Our ref: OUT22/9260

Subject: **Western Coal Services (SSD 5579) – MOD 4 RTS**

Detailed advice to DPE Planning & Assessment regarding the Western Coal Services (SSD 5579) Mod 4 RTS

Figure 1: Modification 4 Elements

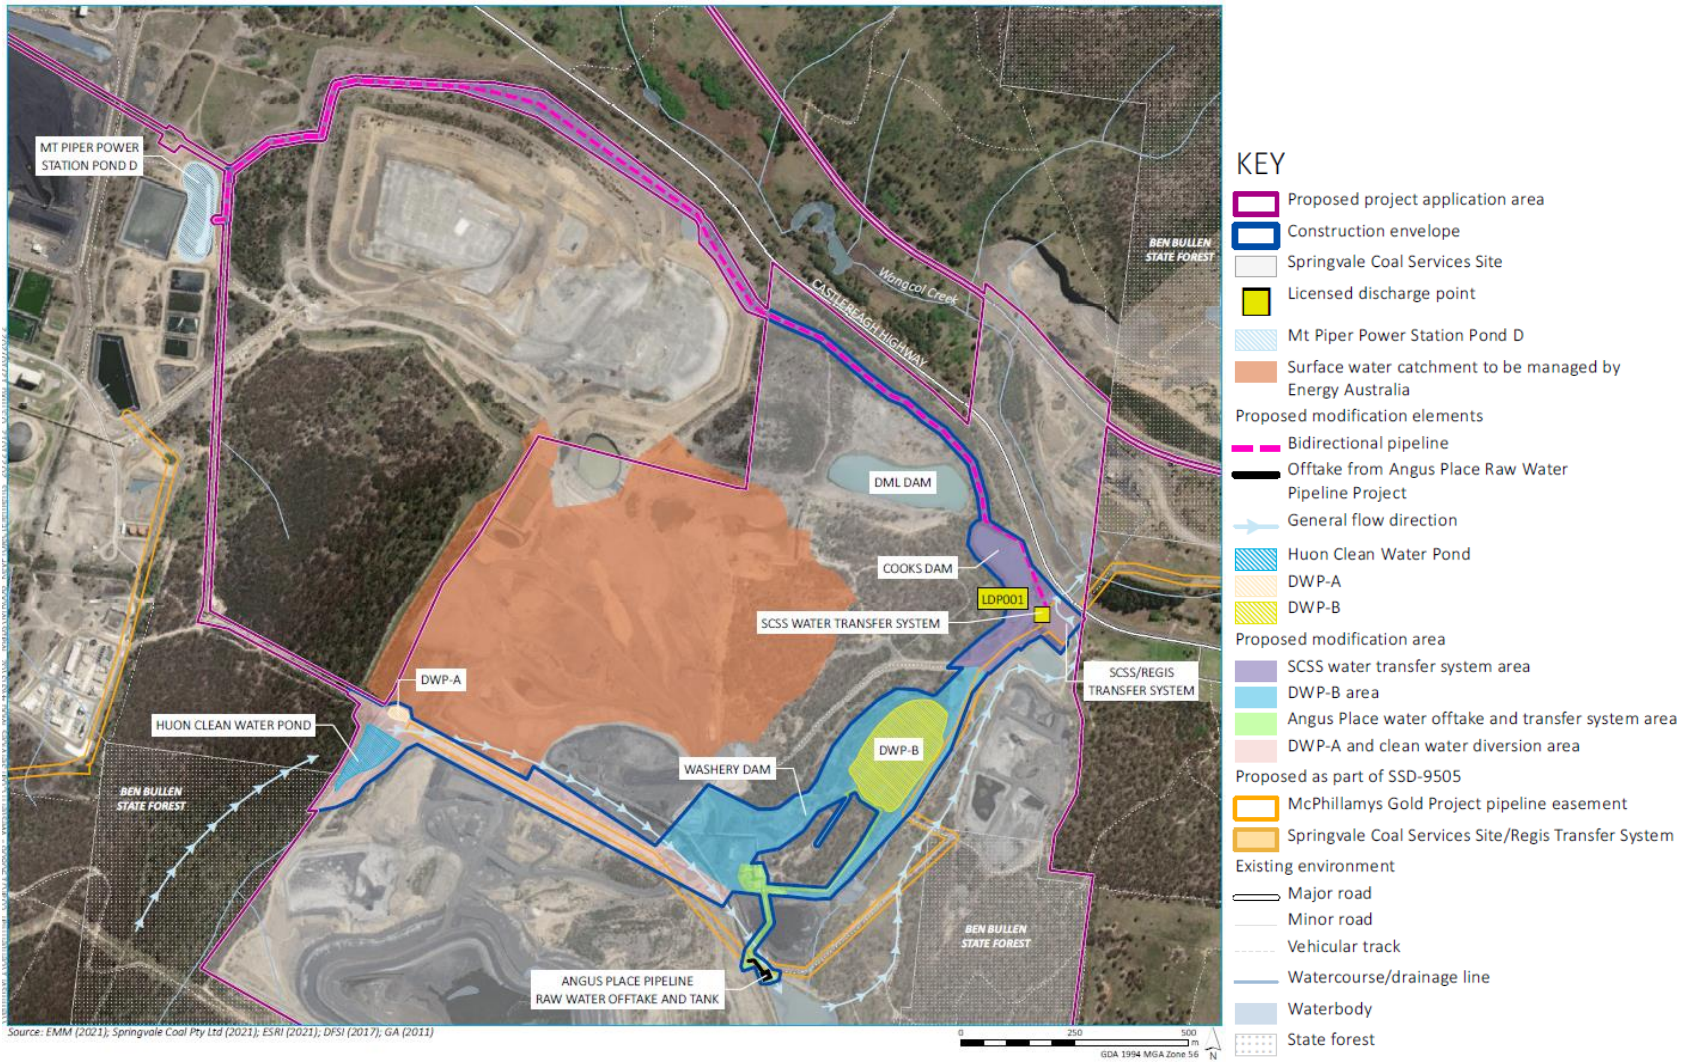
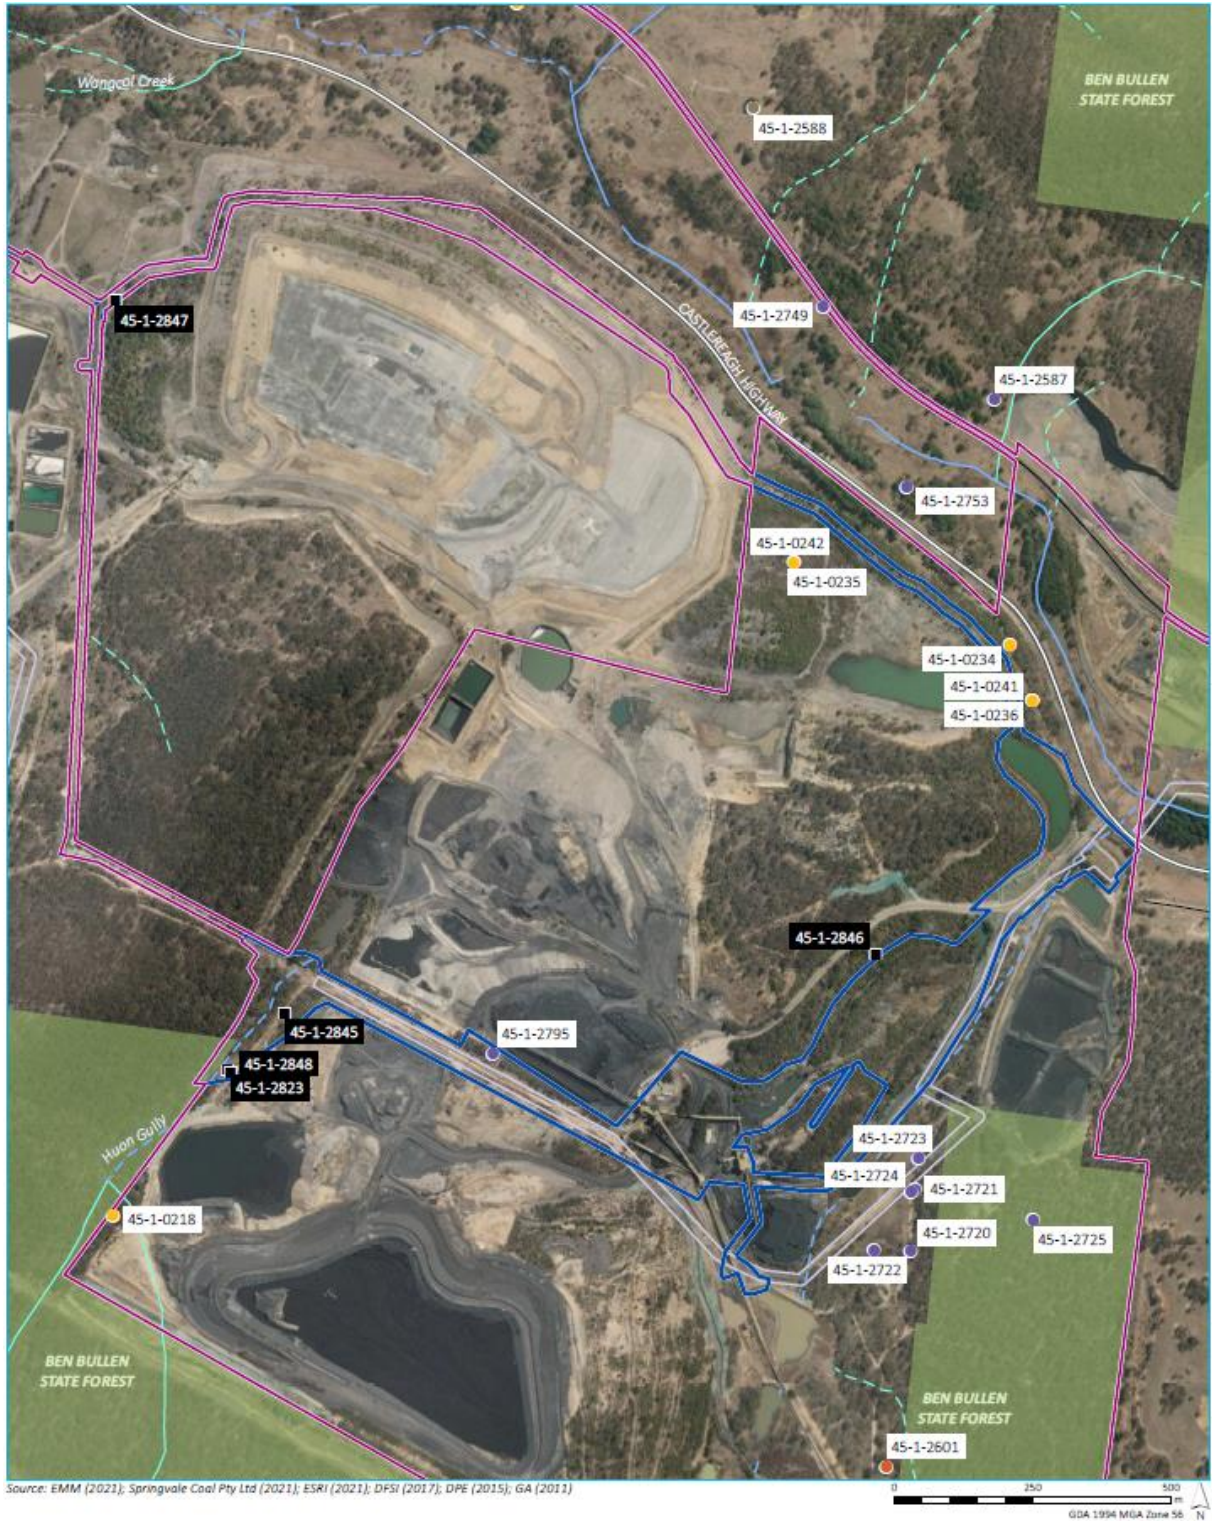
That the proponent demonstrates sufficient surface water entitlement can be obtained for the projects water take from pumping water out of the Huon Clean Water Pond and DWP-A. The department advises there are significant limitations in entitlement availability in the relevant water source and recommends this be acknowledged as a significant risk and addressed prior to determination.

As both storages are to be located on third order watercourses and are within a water source, a Water Access Licence (WAL) with sufficient entitlement is required to account for water take when water is pumped out of these storages. Whether the water is returned to the water source does not remove the requirement to account for the original water take. Based on the water balance model, a maximum of 137ML/yr and 15ML/yr is predicted to be pumped out from the Huon CWP and DWP-A respectively. The need to hold entitlement for this water take was raised in the department's response to the EIS and is yet to be adequately addressed. Significant limitations on water entitlement availability as highlighted in our response to the EIS indicate a significant risk of not being able to acquire the necessary entitlement. There are currently 211 units of issued entitlement in the relevant water source, of which 145 units are held in a single WAL.

That the proponent provides further clarification on the management of clean and dirty water separation from the Huon CWP into Lamberts Gully. This is to assist in addressing a query originally raised on review of the EIS.

The EIS and the RTS indicates clean water will be diverted from the Huon Clean Water Pond to the Main Sediment pond and then released into Lamberts Gully. The department considers the Main Sediment Basin to capture dirty water from upstream as Section 3.5.3 of the EIS identifies this basin as part of the dirty water management system, with the requirement for water entering this basin to require settling time before discharge. If the water diverted from the Huon CWP is clean, it is recommended it be diverted directly into a clean section of Lamberts Gully. Alternatively, if all water captured in the Main Sediment Basin is clean, further clarification is required.
